TOWN AND COUNTRY PLANNING ACT 1990 NON MATERIAL AMENDMENT

Reference: H16-0656-25

Location: 117a Albion Street Spalding Lincolnshire

Description: Erection of two-storey detached dwelling - Approved under H16-0748-21.
Amendments to use TBS Audley Antique brick (Red), white cement instead of ordinary cement & light green UPVC windows & doors

Elevation 01 - Front

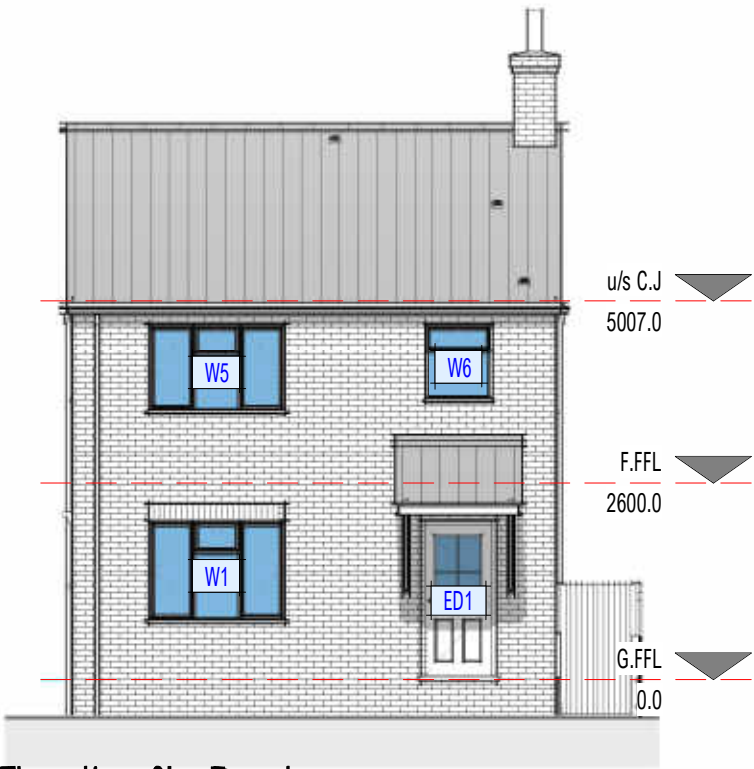
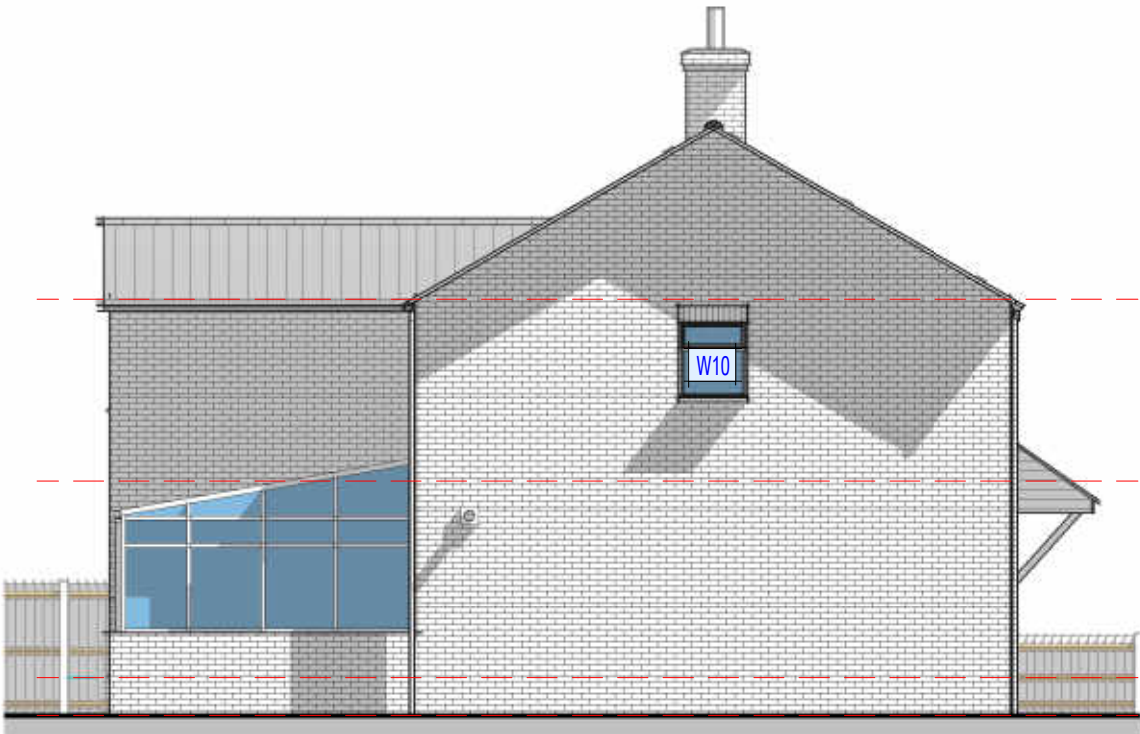
- 1 The proposed amendment seeks to change the approved materials from Hampton Rural Blend bricks to TBS Audley Antique, from ordinary cement to white, and from white UPVC doors and windows to green UPVC doors and windows. This amendment is subject to the details set out in drawing ref 2556/04 Rev F, 2556/01 Rev H and email dated 28/07/25. This change is not considered to materially affect the purpose of the conditions or the planning permission and is therefore acceptable.
